**SURVEYORS AFFIDAVIT OF CORRECTION
CARRIAGE MEADOWS NORTH FILING NO. 1
RECEPTION NO. 218714242**

THAT: I AM A LICENSED PROFESSIONAL LAND SURVEYOR IN THE STATE OF COLORADO AND
THAT: I PREPARED THE PLAT OF "CARRIAGE MEADOWS NORTH FILING NO. 1" AS RECORDED UNDER RECEPTION NO. 218714242 IN THE RECORDS OF EL PASO COUNTY, COLORADO.

FINAL PLAT
 CARRIAGE MEADOWS NORTH
 FILING NO. 1
 JOB NO. 70-055
 DATE PREPARED: 12/06/2017
 DATE REVISED: 01/29/2018

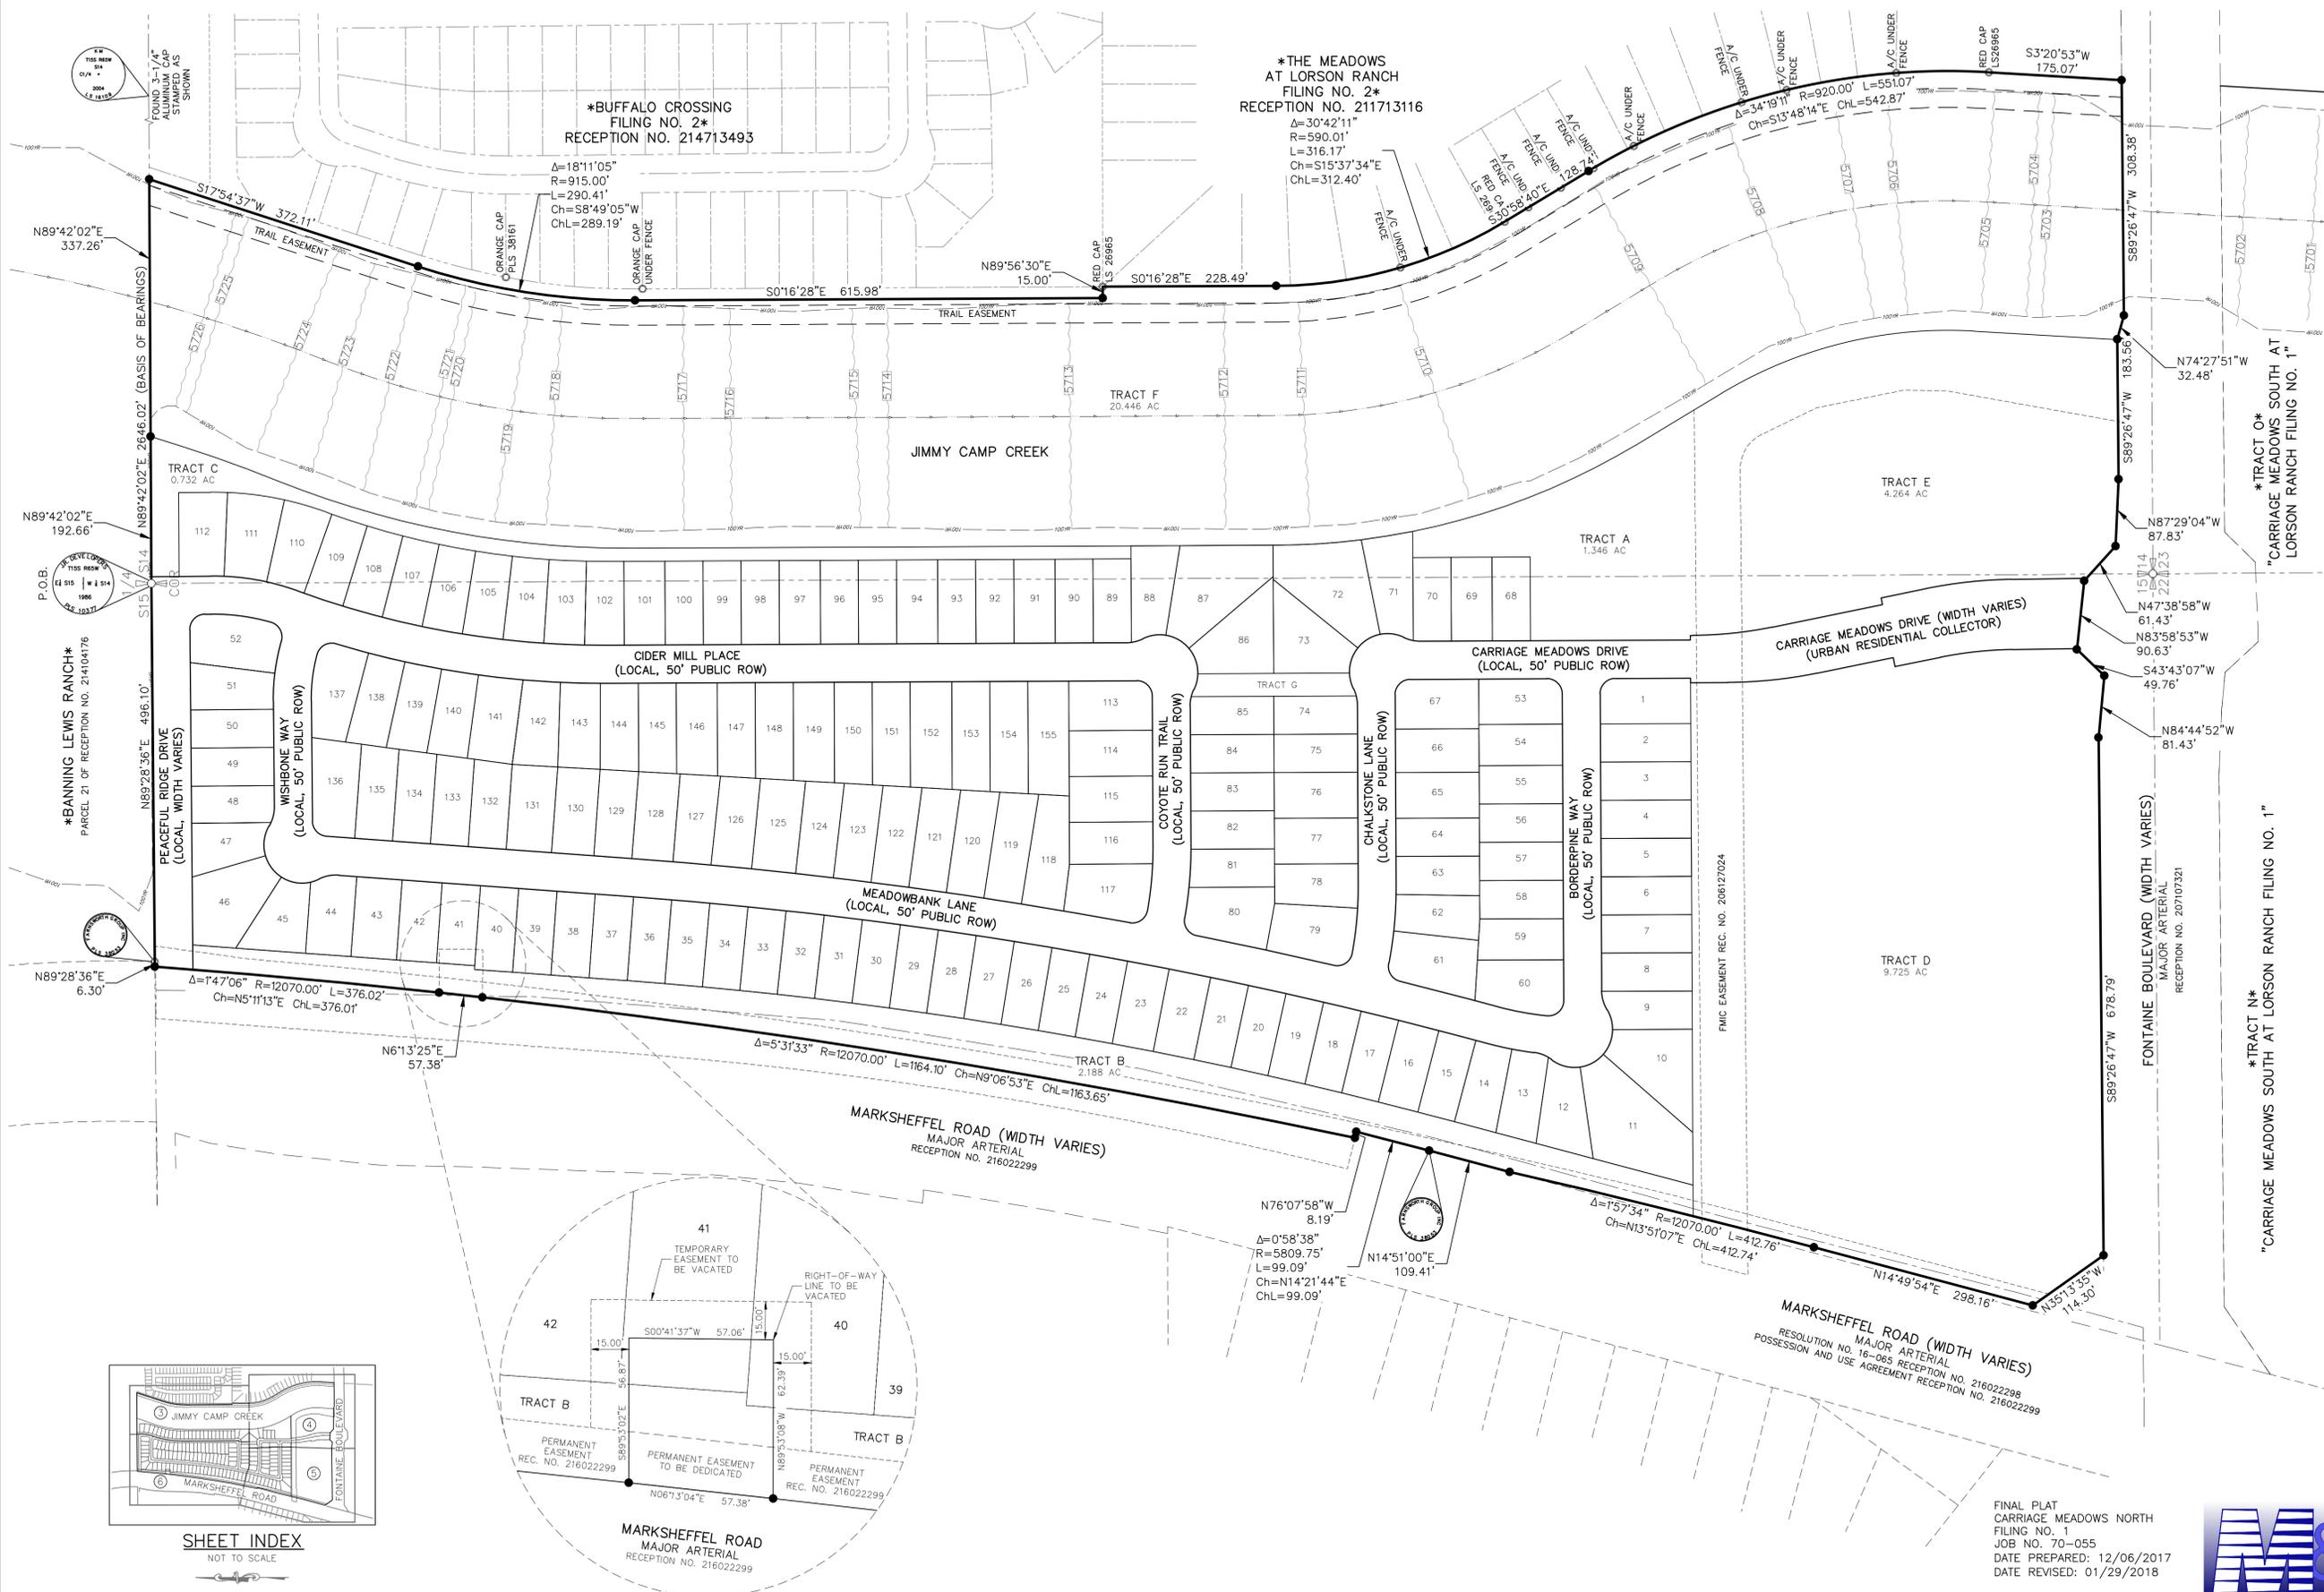
AFFIANT FURTHER STATES THAT: CERTAIN ERRORS WERE MADE ON THE FIRST SHEET OF SAID PLAT AS FOLLOWS:

AS STATED ON THE PLAT UNDER "FEES":

<i>Geo</i> DRAINAGE FEE:	CREDITS USED THIS FILING	\$ 470,948.00
JIMMY CAMP CREEK SURETY FEE:	CREDITS USED THIS FILING	\$ 210,869.00
BRIDGE FEE:	CREDITS USED THIS FILING	\$ 22,027.00
SCHOOL FEE:	<u>FEES NOT DUE PER THE SCHOOL LAND AGREEMENT AS RECORDED AT RECEPTION NO. 212042170</u>	
PARK FEE:	<i>Area 4</i>	\$ 66,650.00
URBAN PARK FEE:	<i>Area 4</i>	\$ 42,106.00

IS HEREBY AMENDED TO READ;

<i>Geo</i> DRAINAGE FEE:	CREDITS USED THIS FILING	\$ 470,948.00 296,184.00
JIMMY CAMP CREEK SURETY FEE:	CREDITS USED THIS FILING	\$ 210,869.00 132,618.00
BRIDGE FEE:	CREDITS USED THIS FILING	\$ 22,027.00 13,853.00
SCHOOL FEE:	<u>FEES NOT DUE PER THE SCHOOL LAND AGREEMENT AS RECORDED AT RECEPTION NO. 212042170</u>	
PARK FEE:	<i>Area 4</i>	\$ 66,650.00
URBAN PARK FEE:	<i>Area 4</i>	\$ 42,106.00

AFFIANT FURTHER STATES THAT THE AFOREMENTIONED PLAT OF "CARRIAGE MEADOWS NORTH FILING NO. 1" IS HEREBY CORRECTED TO CONFORM TO THE ABOVE DESCRIBED AFIDAVIT AS IF SAID CORRECTION HAD BEEN RE-RECORDED WITH THE PROPER FEE AMOUNTS AS SHOWN HEREON.
